Planning Application Ref: Y/37/20/T

Location: Shoulders, Main Road, Yapton, BN18 0EU

Description of works: 1no. red oak (T1) prune all lateral overhanging branches back to 3m. 1no. maple tree (T2) prune all lateral branches overhanging back to 2m. 1no. maple tree (T3) prune all lateral branches overhanging back to 2m. 1no. red oak tree (T4) prune all lateral branches to 4m

Sketch plan

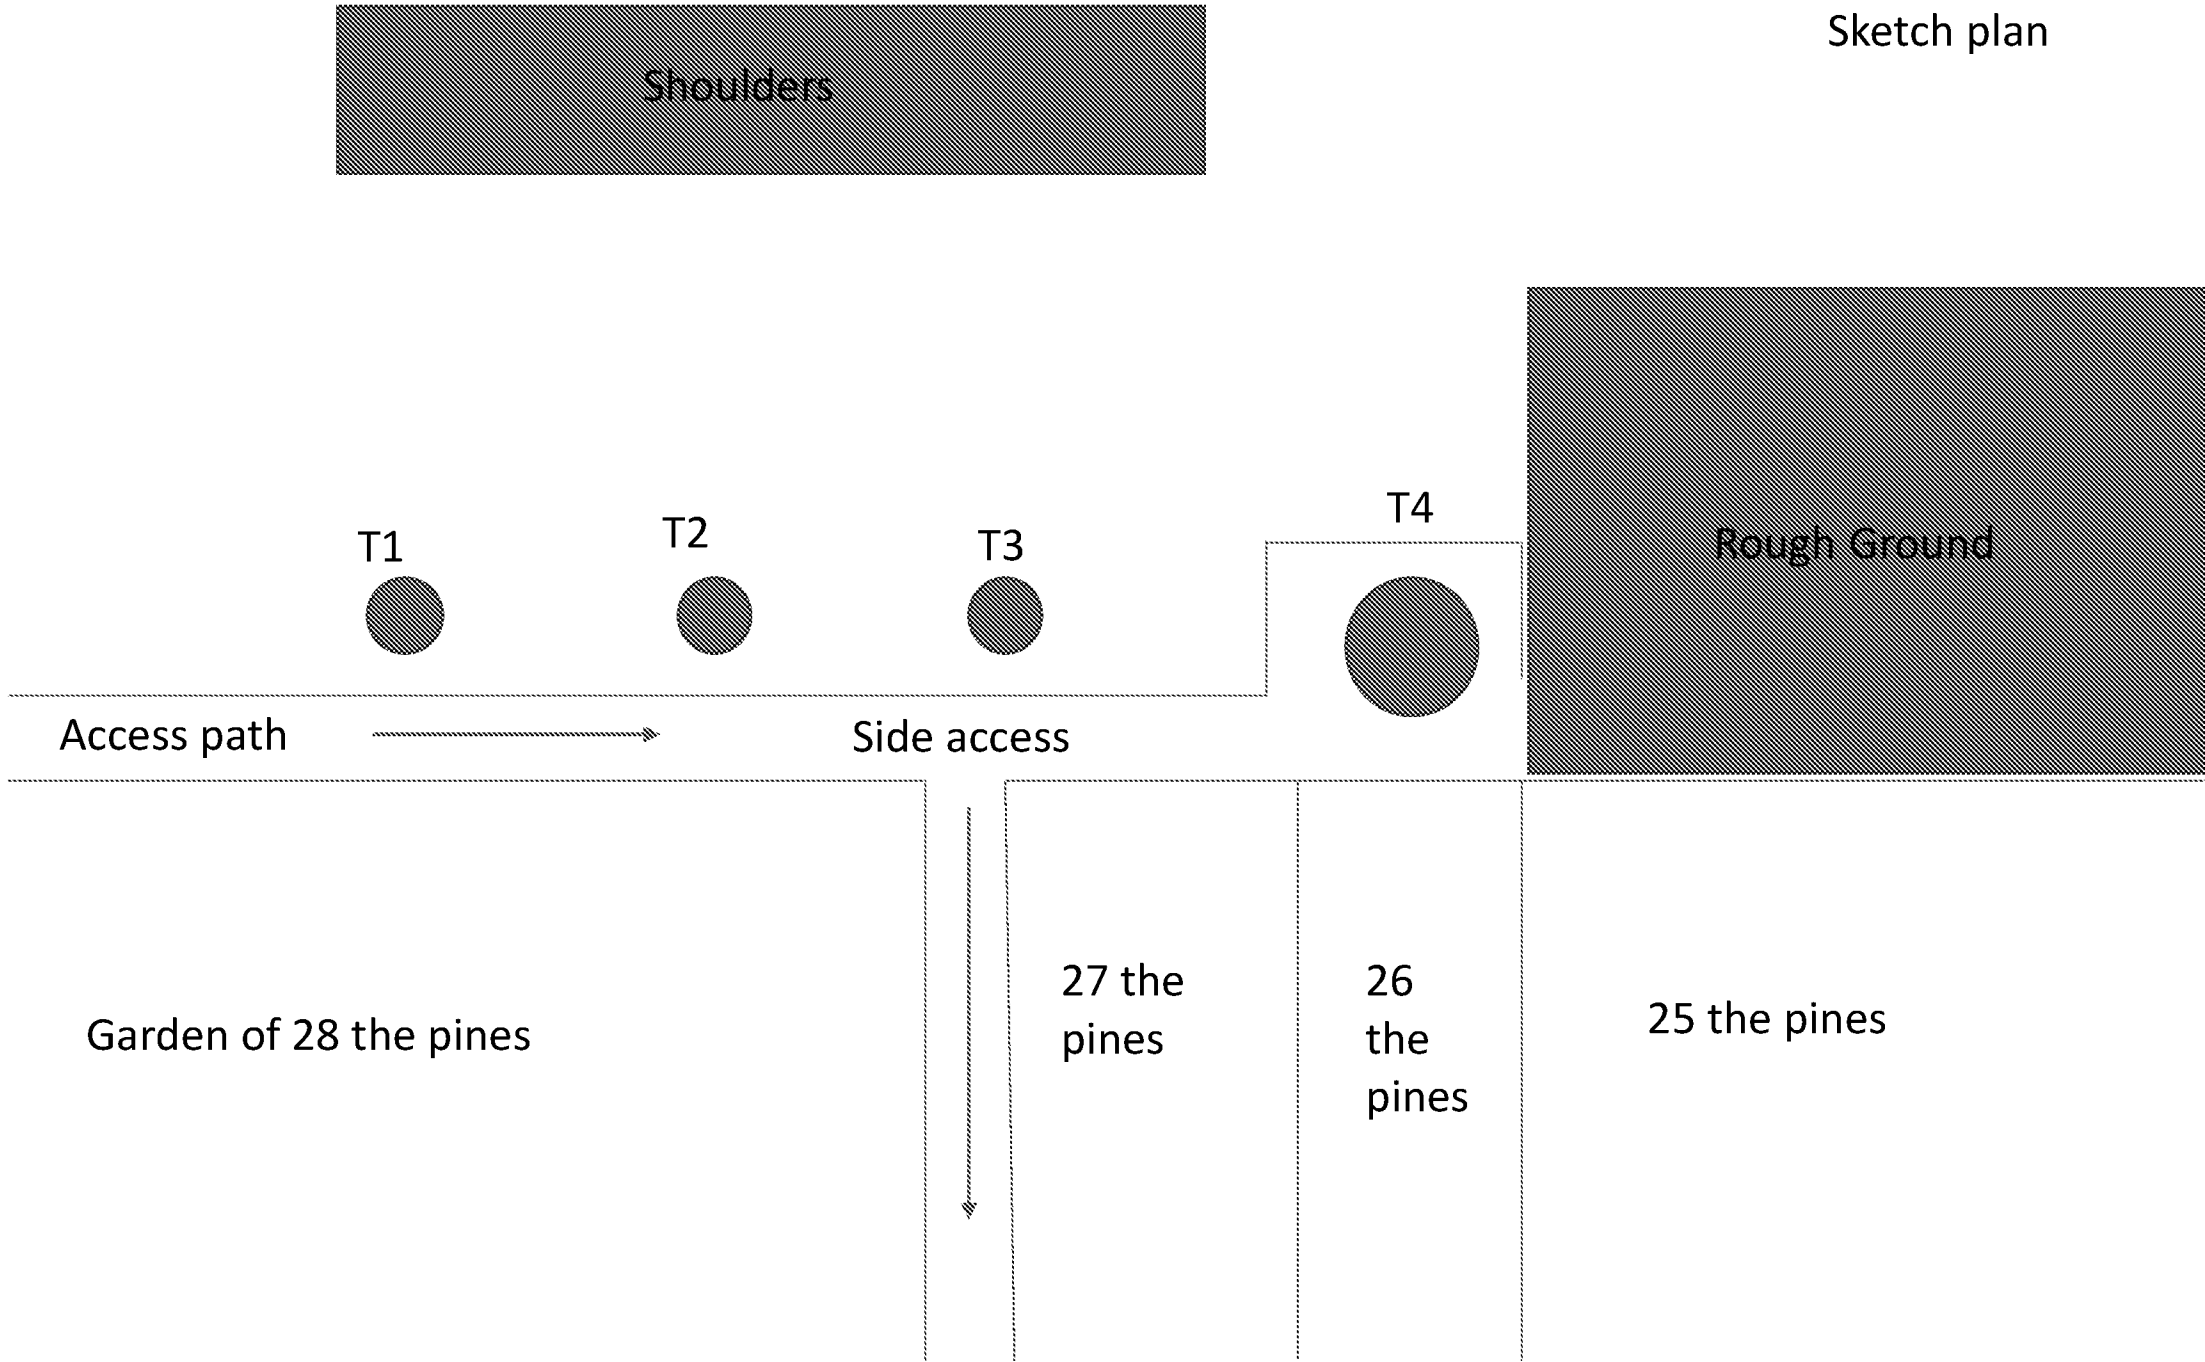
- T1 - This tree appears to be outwardly healthy and stable with an attractive crown profile. There is evidence of past reduction pruning, from which it has grown-on well. I have been unable to retrieve a record of past consent granted by the local planning authority for such work.

- T2 & T3 - These trees appear to be outwardly healthy and stable with an attractive shared crown profile. There is evidence of past reduction pruning, from which they have grown-on well. I have been unable to retrieve a record of past consent granted by the local planning authority for such work.

- T4 - I am aware that there is local concern about the potential for this tree to fail. My own ground-level visual assessment of the tree did not suggest an obvious and immediate threat of significant harm to person(s) or property. That said, it is clearly a distressed tree with heavily asymmetric form (weighted to the south) and a high percentage of limb/branch dieback predominantly found on its north aspect.

- The extent of boundary overhang is proportionate with the height and proximity of the trees. Reduction of the lateral spread back to the boundary line has not been justified on arboricultural grounds.

- The trees T1, T2 & T3 are a significant feature in the local landscape and appear to be in adequately sound and healthy condition. The tree surgery proposed in the application would result in excessive reduction of their landscape impact and undue detriment to the visual amenities of the locality.

- T4 is a genuine safety concern, especially for those residents living to the south for whom any wholesale collapse of the tree could be catastrophic. Noteworthy observations from brief ground-level visual assessment include; Large areas of bark detaching from low on the main stem, evidence of recent stem bleeding, triangular bark wound N side of stem base (Phytophthora?) and substantial accumulation of garden spoil around its base. A reduction in the weight of its south-tending limb and branch framework is entirely justified without further detailed investigation.

- Reduce radial crown spread on south aspect only by approximately 2metres to leave a finished, minimum branch length of 4metres.

Part a) Where whole branches are to be removed and final cuts made close to the trunk or branch union they are to be made as shown in Figure 2 of BS3998:2010

Part b) Where branches are to be shortened back the final cuts are to be made at the correct angle shown in BS3998:2010 and adjacent to a live bud or lateral.
